ADDENDUM

Project: Science Building Research Wing Expansion

Project No. 03049

Addendum: No. 1

ALTERNATE #5
3 SECOND FLOOR PART PLAN - RENOVATION
W2.1 1/8" = 1'-0"

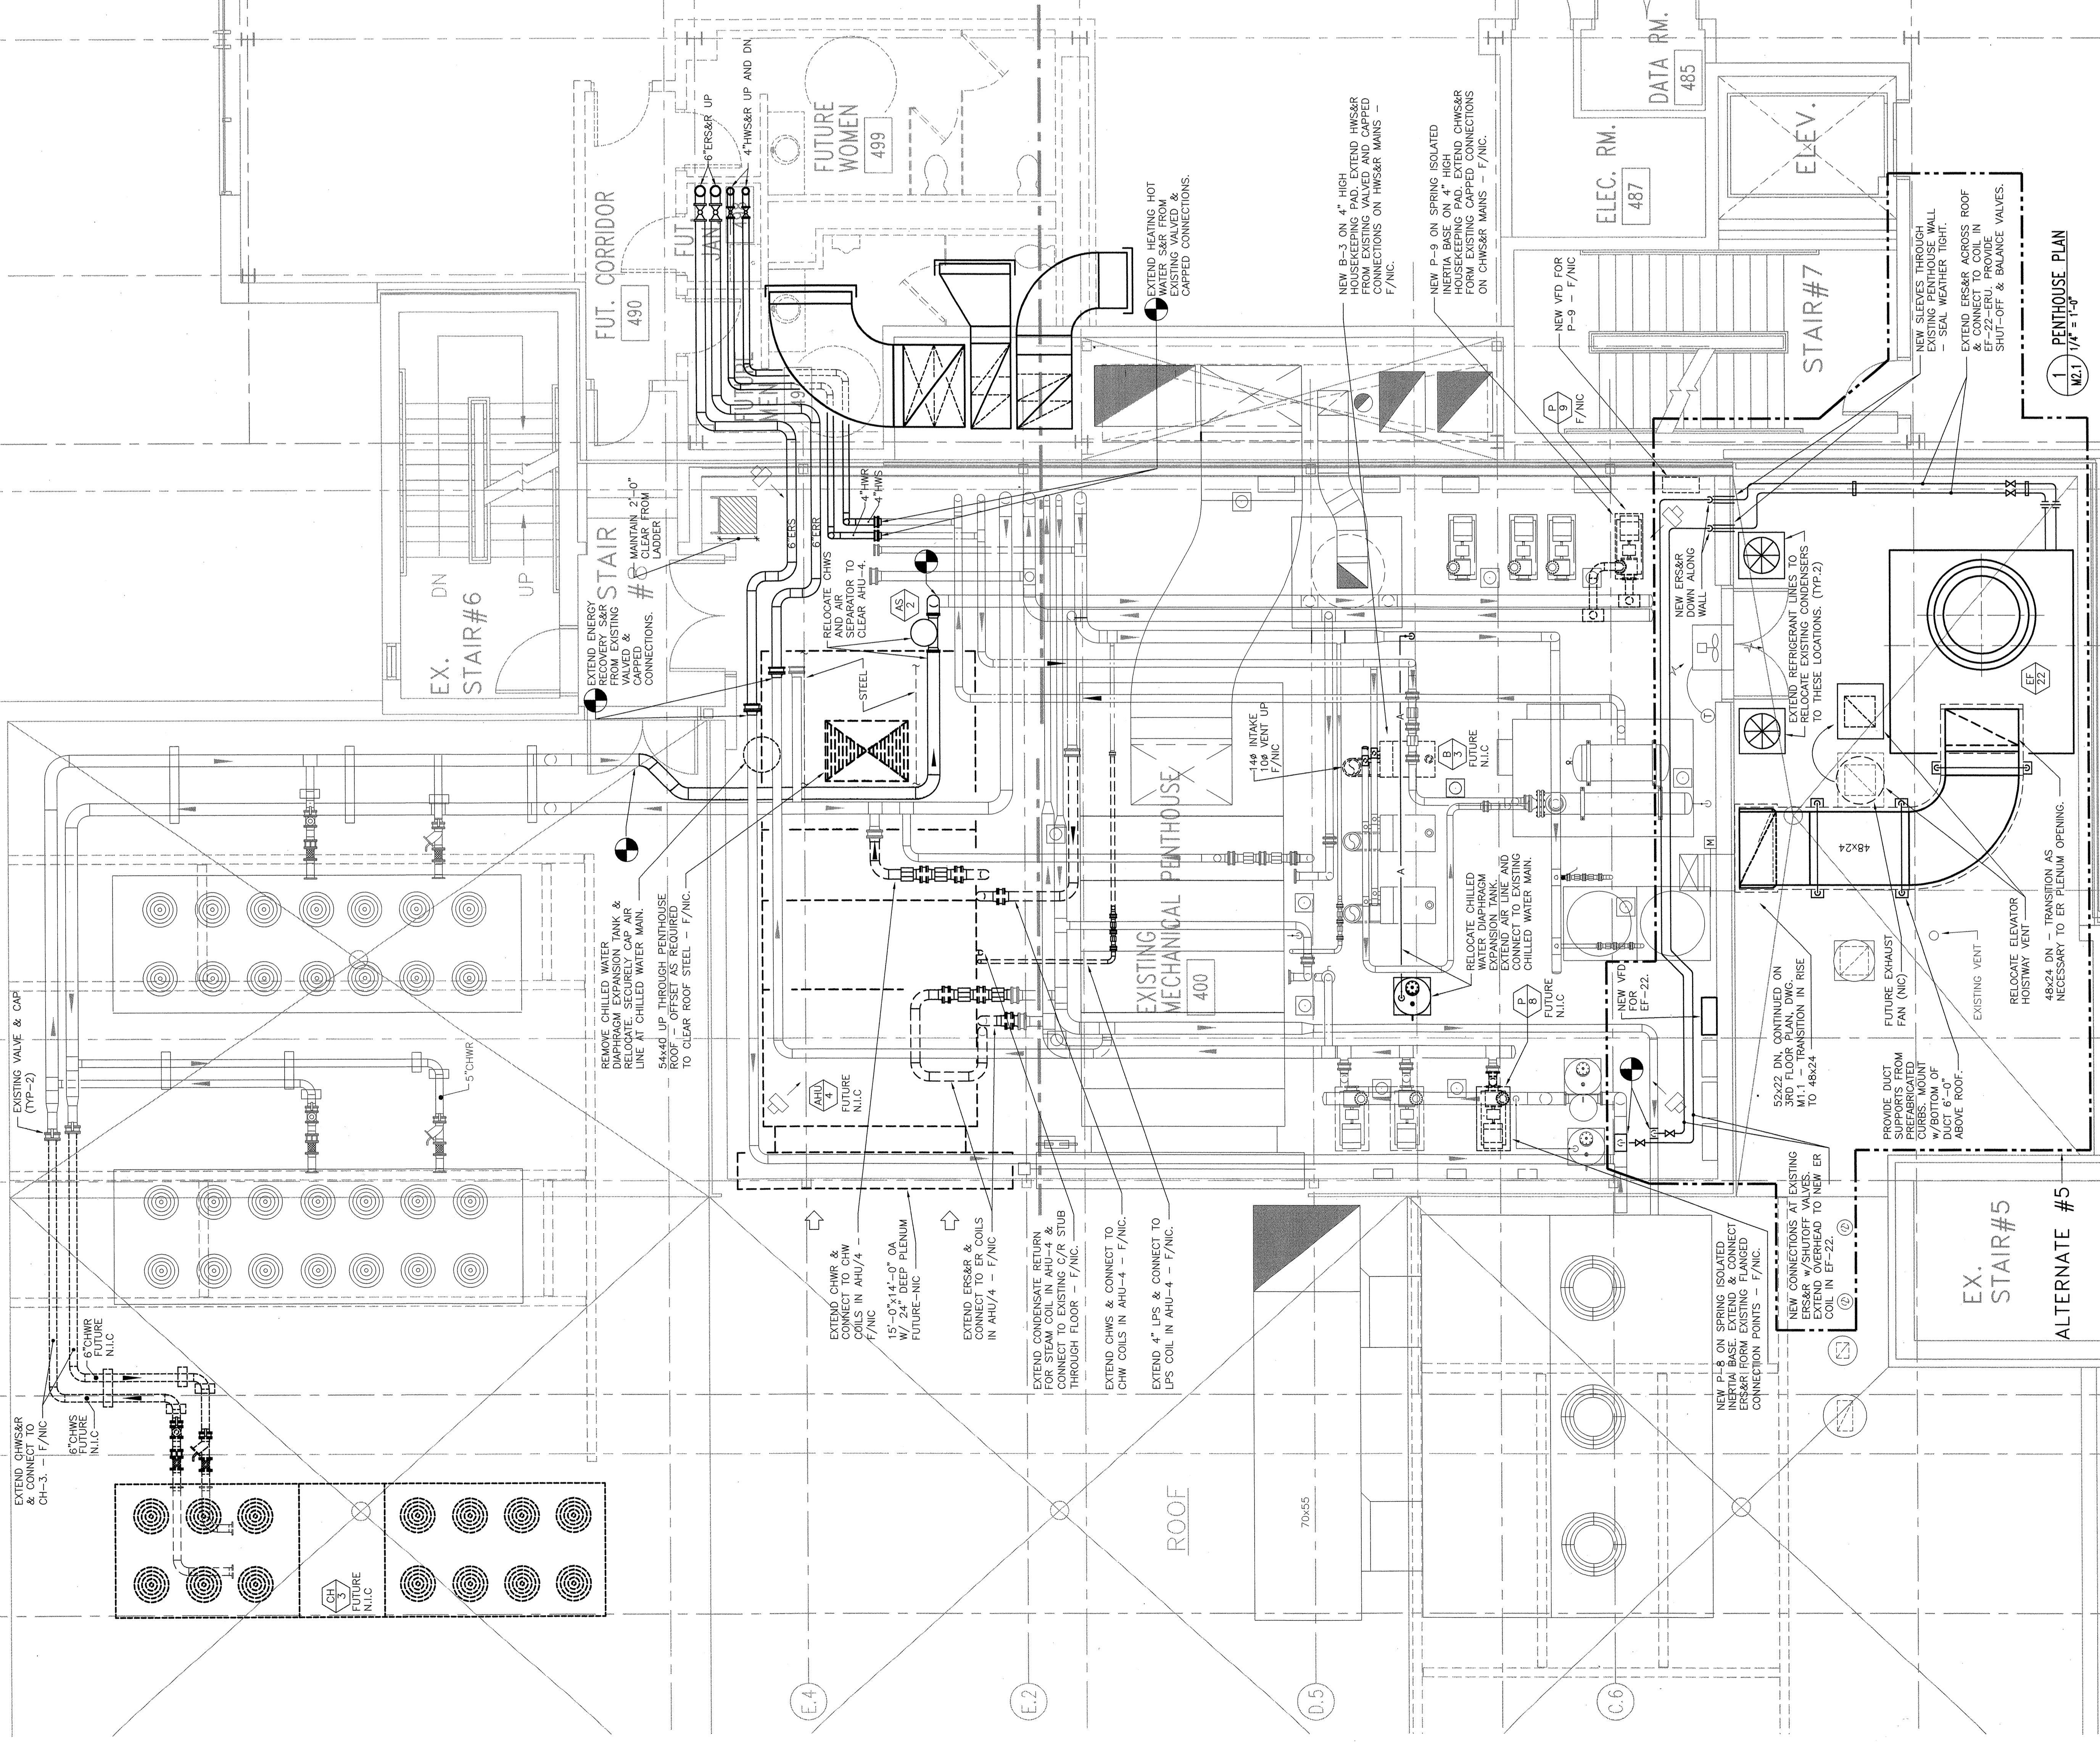
1. Change note at EF/22 to read "Extend 4" ERS7R across roof I connect to coil in EF-22-ERU. Provide shut-off and balance valves."

ALTERNATE #4
CHILLED WATER CONNECTION DETAIL
SCALE: NONE
W2.2

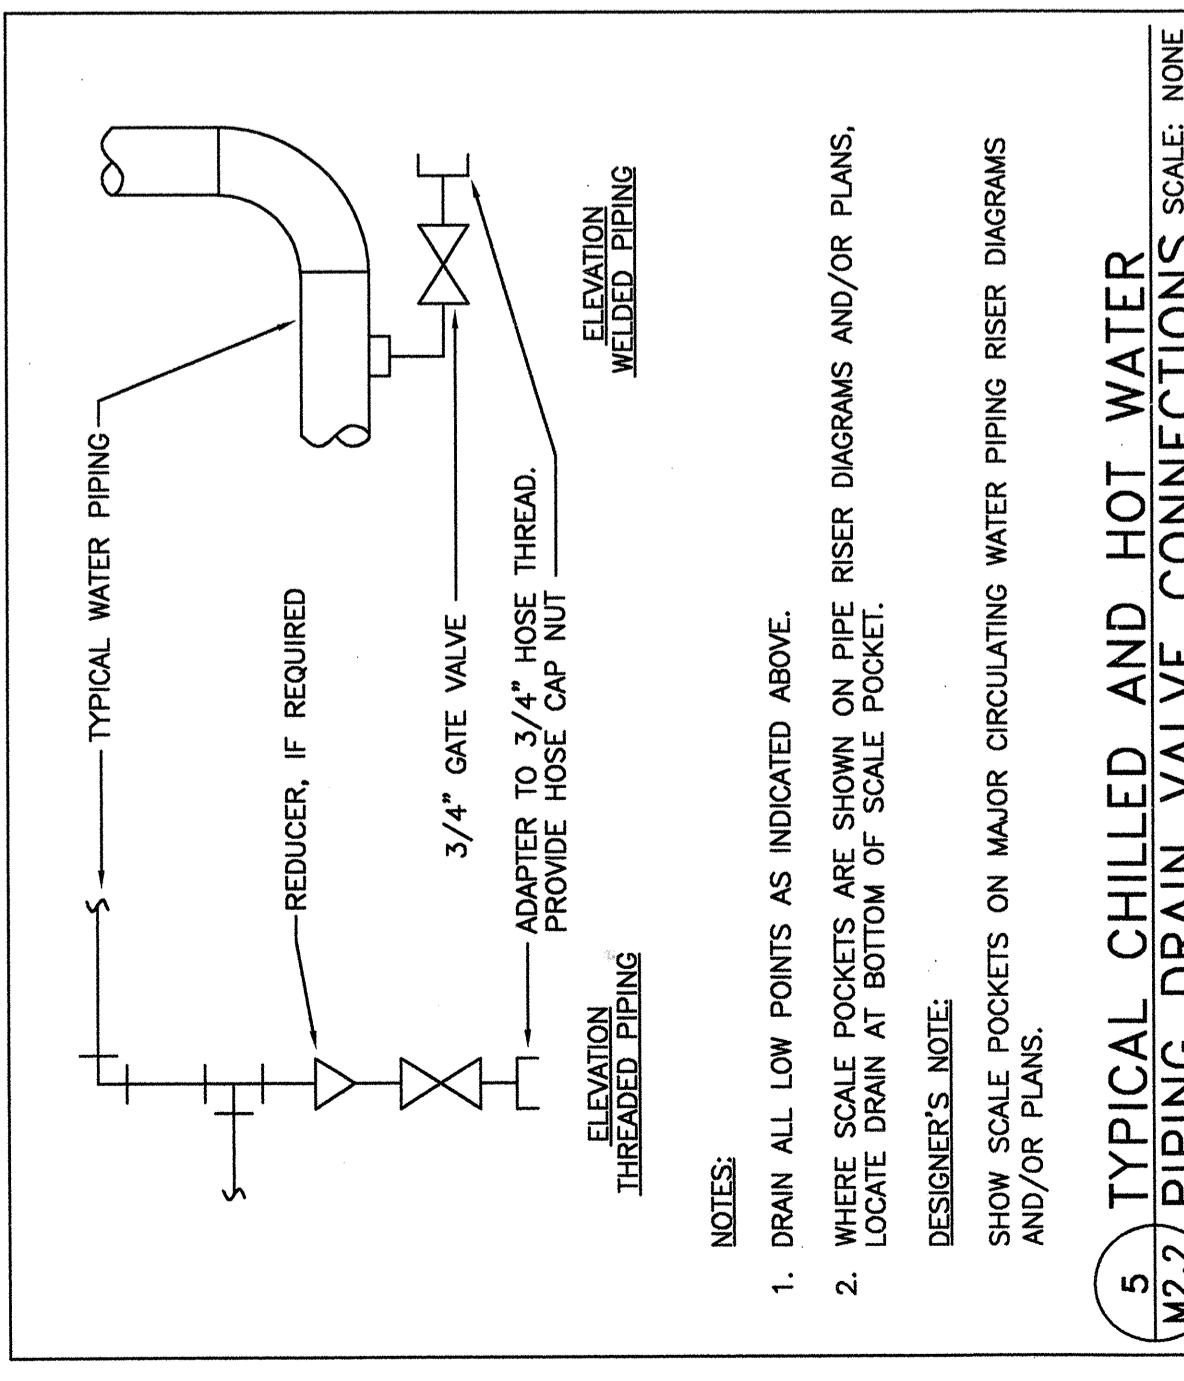
1. Refer to Detail 4/M2.2. Change note to read "Extend 1" chilled water horizontally for cross connection to Science Wing CHWS&R."
